PLANNING CONSULTATION RESPONSE

Application No	<u>2026/0491</u>
Proposal	Change of use from equestrian to residential Change of use from Use Class C3 (Dwellinghouse) to Use Class C2 (Residential Institutions) to operate as a residential care home for adults and young adults with autism and learning disabilities, together with extensions, alterations and conversion of outbuildings, including retrospective planning permission for the erection of Outbuilding 2.
Address	134 Church Hill, Royston, Barnsley, S71 4AQ
Date of Consultation Reply	20/07/26
Consultee	Highways Development Control

Site Plan As Proposed

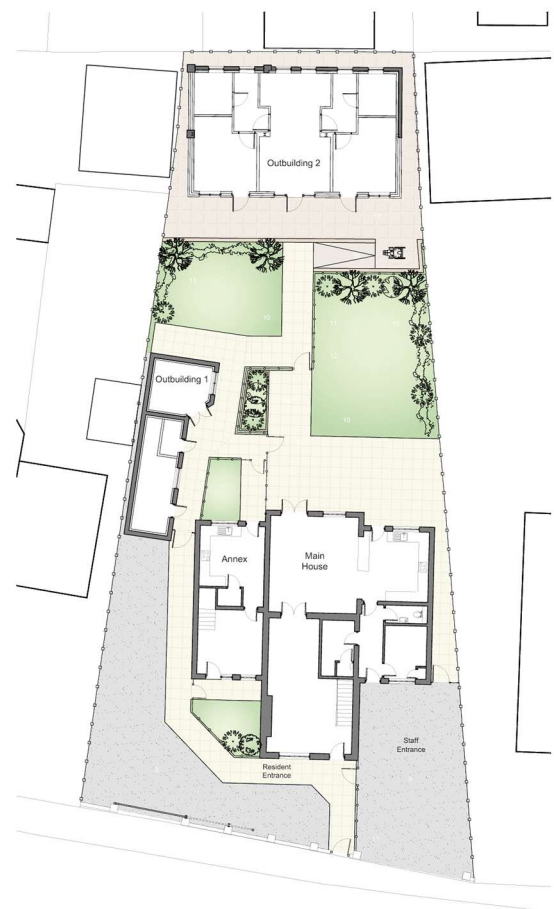
The submitted information states that eight parking spaces would be available within the site, primarily for staff. However, the proposed site plan does not identify eight individual parking bays, their dimensions or how the parking areas would operate. Instead, general gravelled areas are shown on either side of the property. No accessible parking bay is identified, notwithstanding the provision of wheelchair accessible accommodation within Outbuilding 2, and it has not been demonstrated that eight vehicles could be parked while maintaining sufficient space for vehicles to manoeuvre.

A revised site plan should therefore be submitted showing the location and dimensions of all proposed parking spaces, including an appropriately positioned accessible space. The plan should demonstrate that vehicles can enter, park, manoeuvre and leave the site safely without obstructing either vehicular access. Swept paths should also be provided for the largest vehicle that is reasonably expected to attend the premises, taking account of any minibus, wheelchair accessible vehicle, delivery vehicle or patient transport vehicle associated with the operation.
